From: Planning
Sent: 21 May 2021 12:02
To: DC Support
Subject: FW: 21/00588/ADV-2 - Land Including OS7400 5257 4976 2661 And 5257 South Of Salt Way Adj To Bloxham Road Banbury

Planning application:	21/00588/ADV
Location:	Land Including OS7400 5257 4976 2661 And 5257 South Of Salt Way Adj To Bloxham Road Banbury
Description:	2no advertising billboards and house builder flag poles
Type:	Advertisement
Case Officer:	Wayne Campbell

Oxfordshire County Council, as the Local Highways Authority, hereby notify the District Planning Authority that they **object** to the granting of advertisement permission.

# SITE PLAN

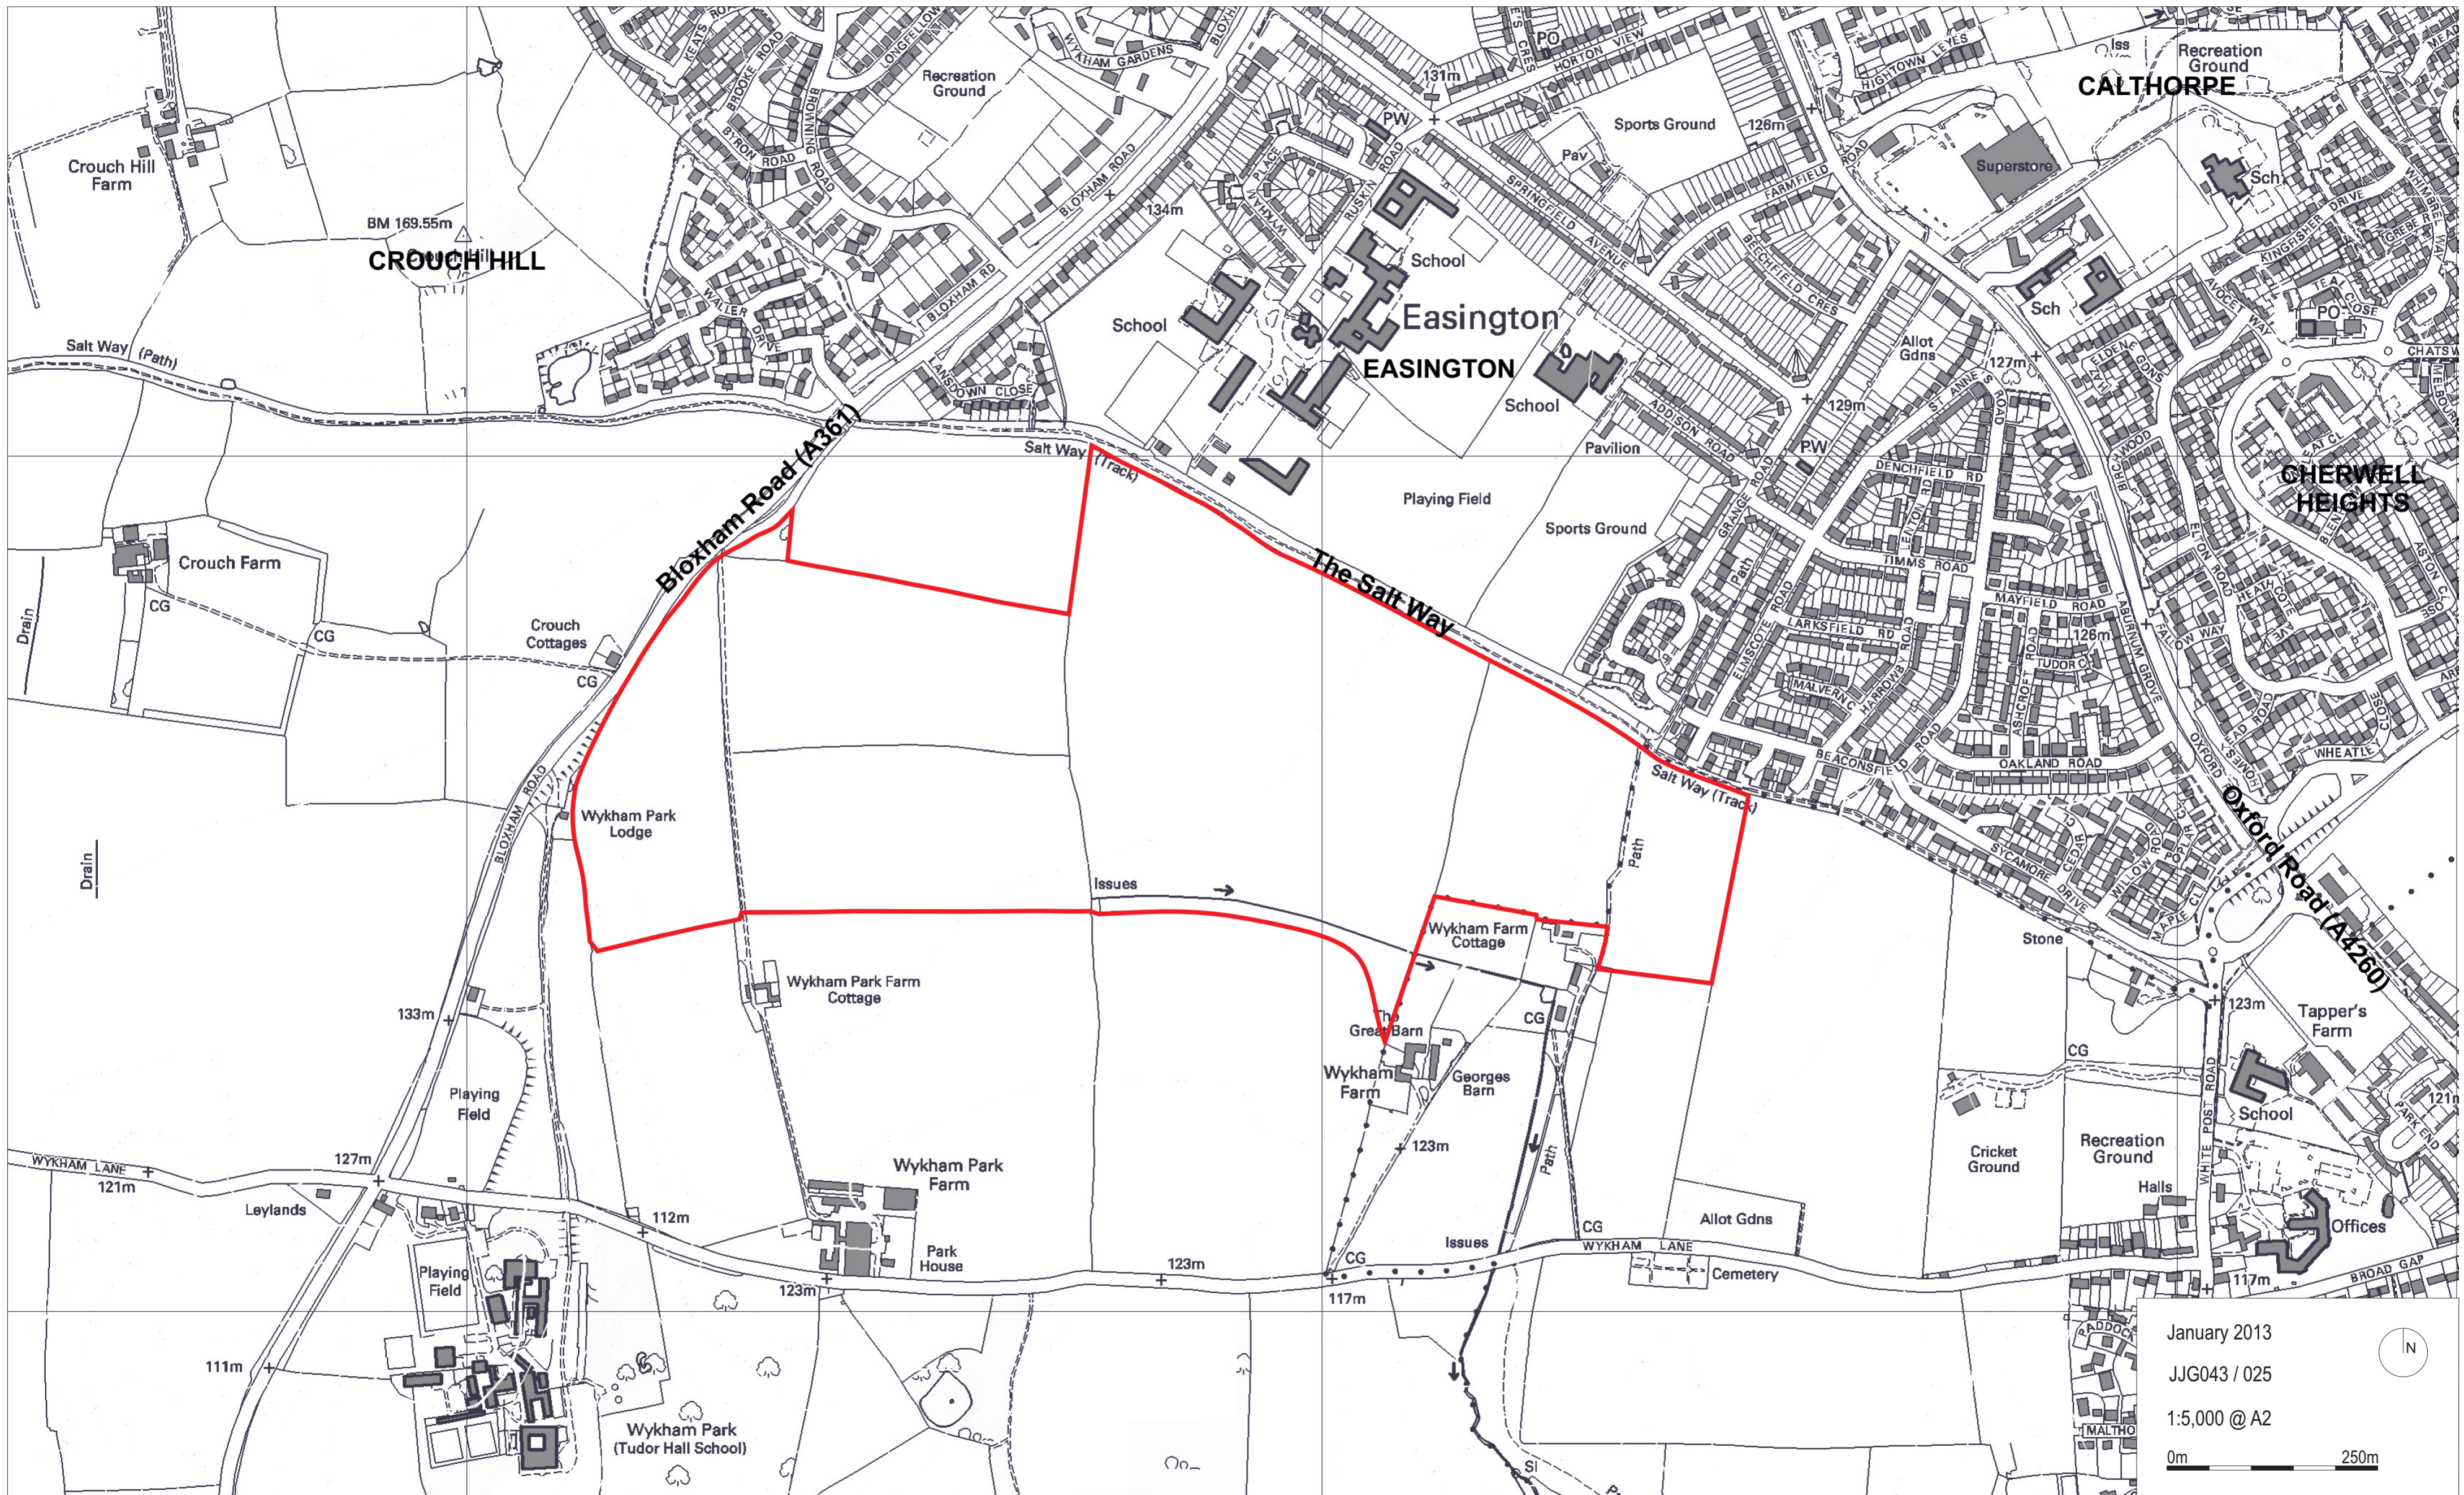
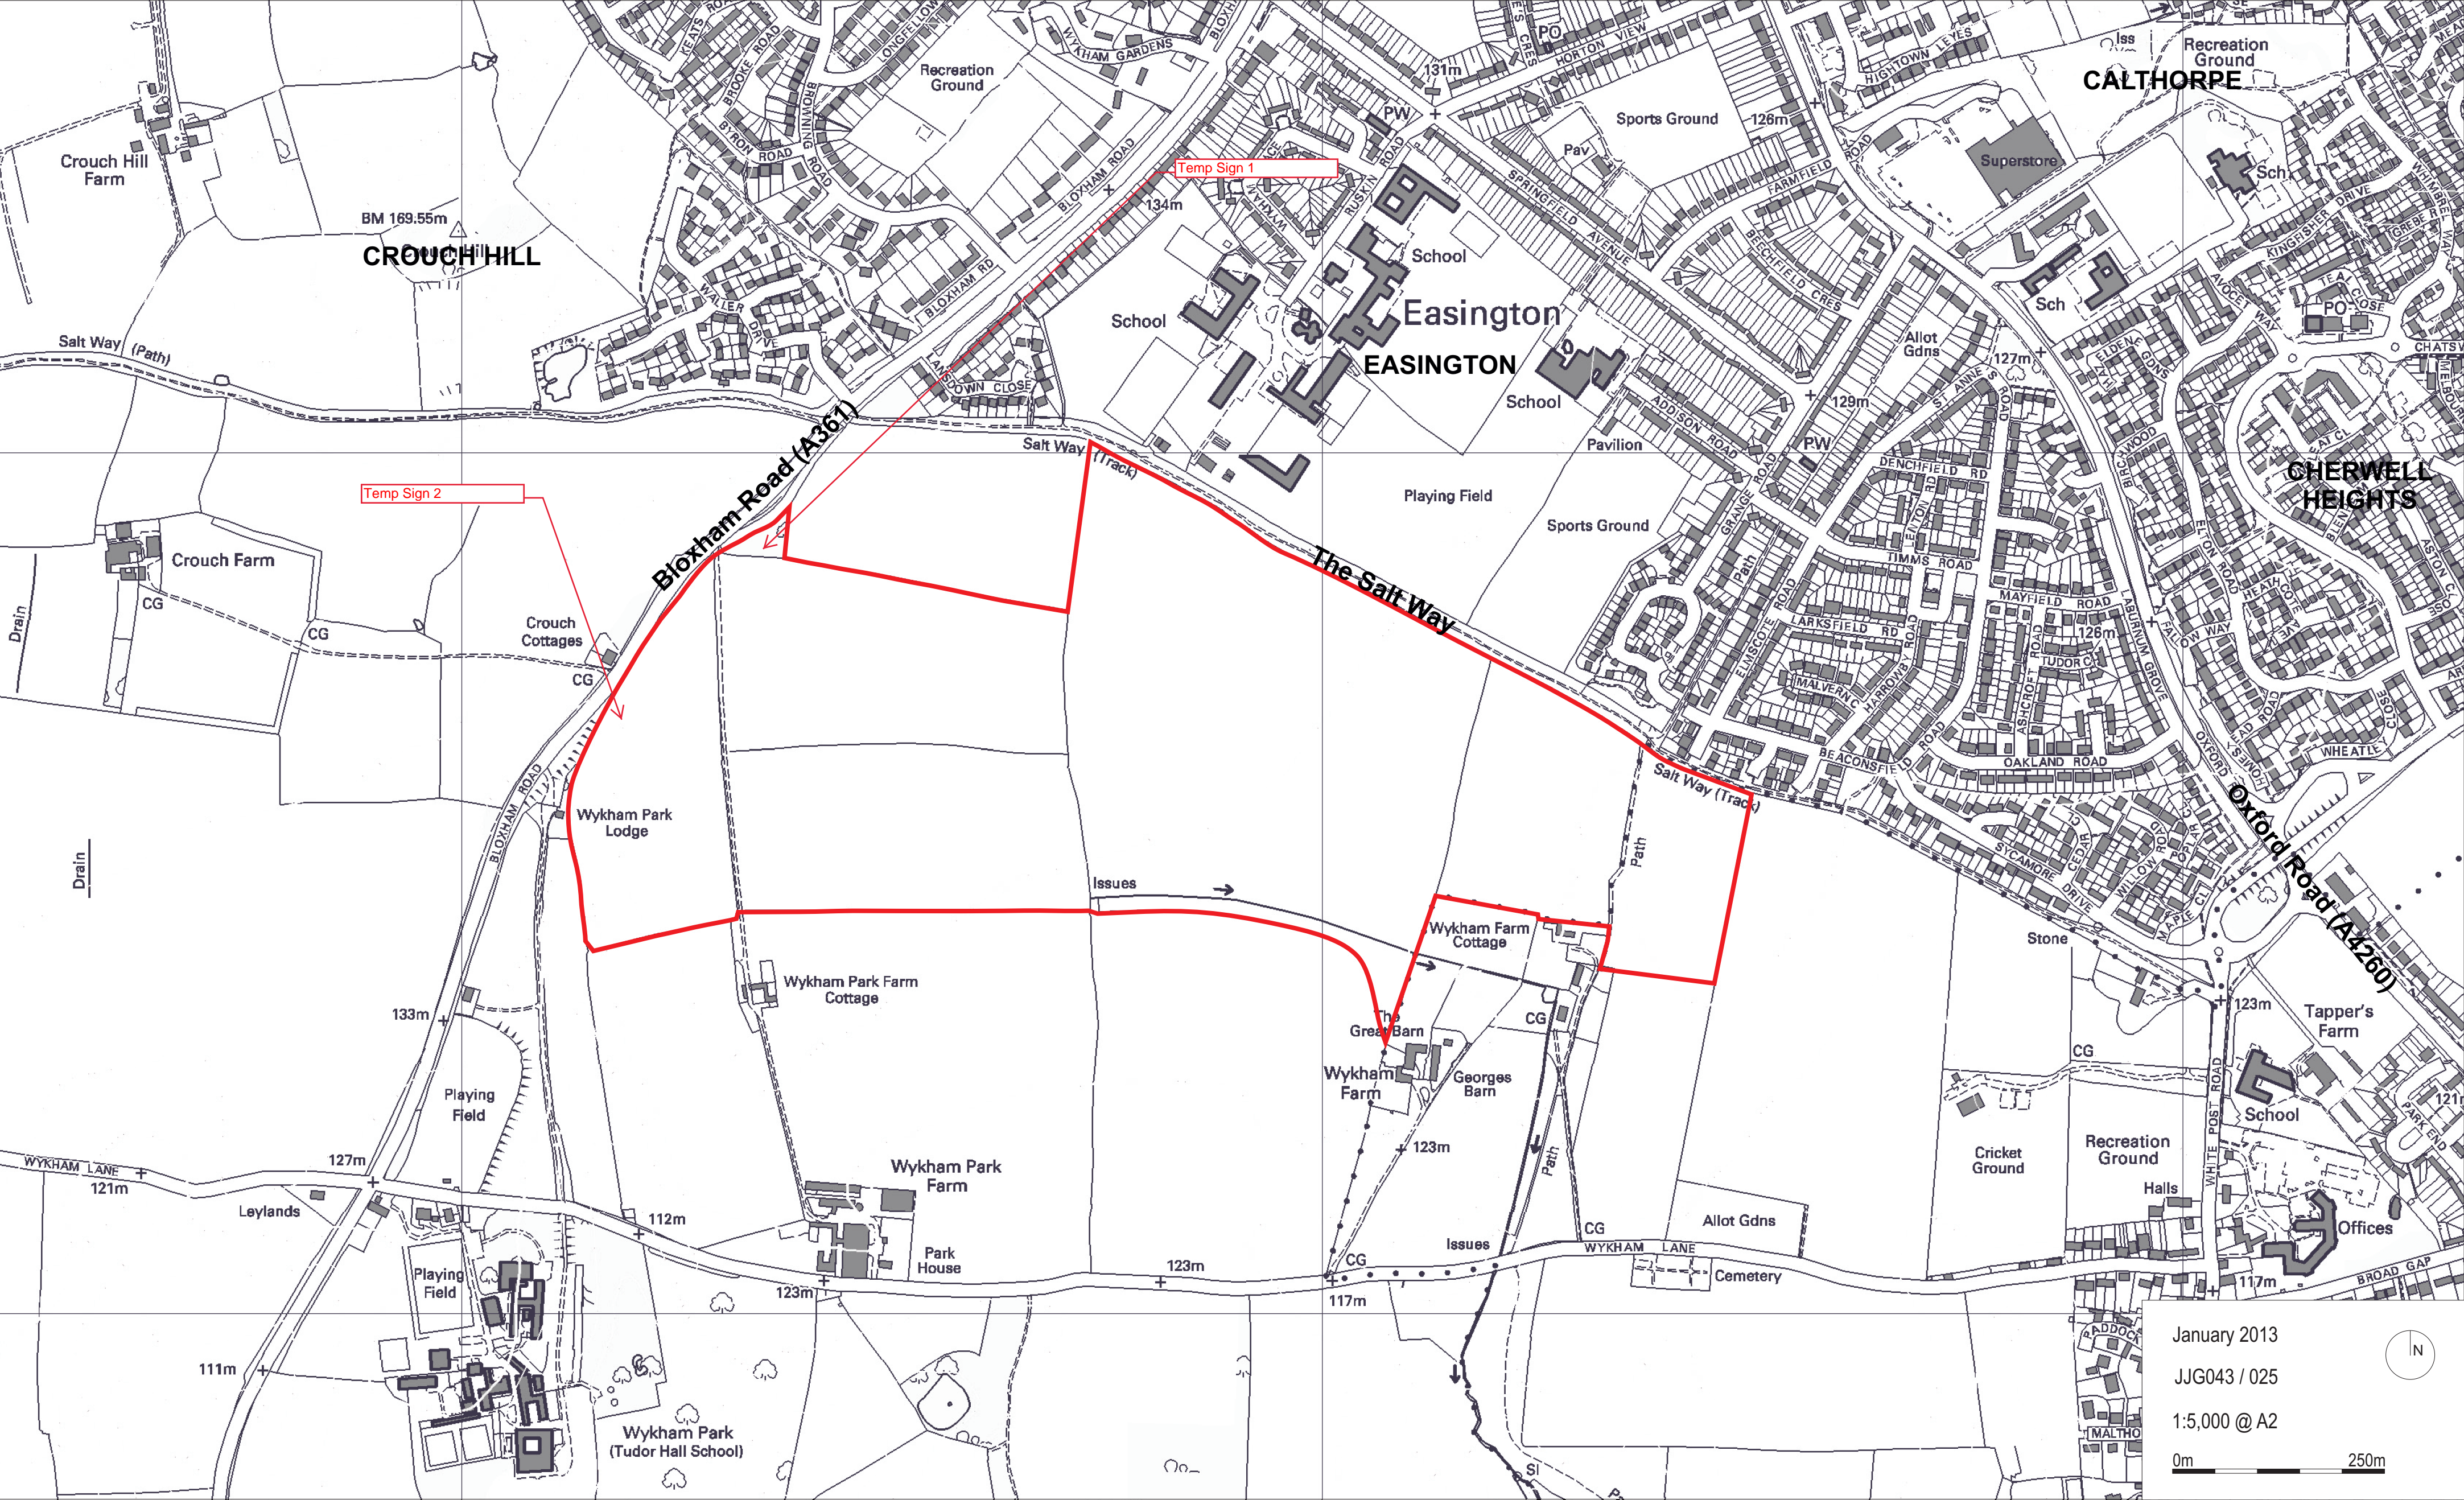
It is unclear from the submitted drawings as to where the proposed 14 flag pole signs (two each) and two billboard signs will be located in relation to the adopted public highway verge, this in addition to there being no reference on any of the submitted drawings as to where the 14 flag pole signs will be located. Further, the submitted site plan, drawing JJG043 appears out of date (January 2013) as it does not appear to show the recently installed roundabout for Parsons Piece, Tyrell and Bloxham Roads.

Finally, it is unclear from the submitted 2013 plans as to the location of the planned second roundabout to facilitate access to this development from the Bloxham Road, nor do the plans show the location of the planned spine road that will connect onto the recently installed highway works on White Post Road, Bodicote.
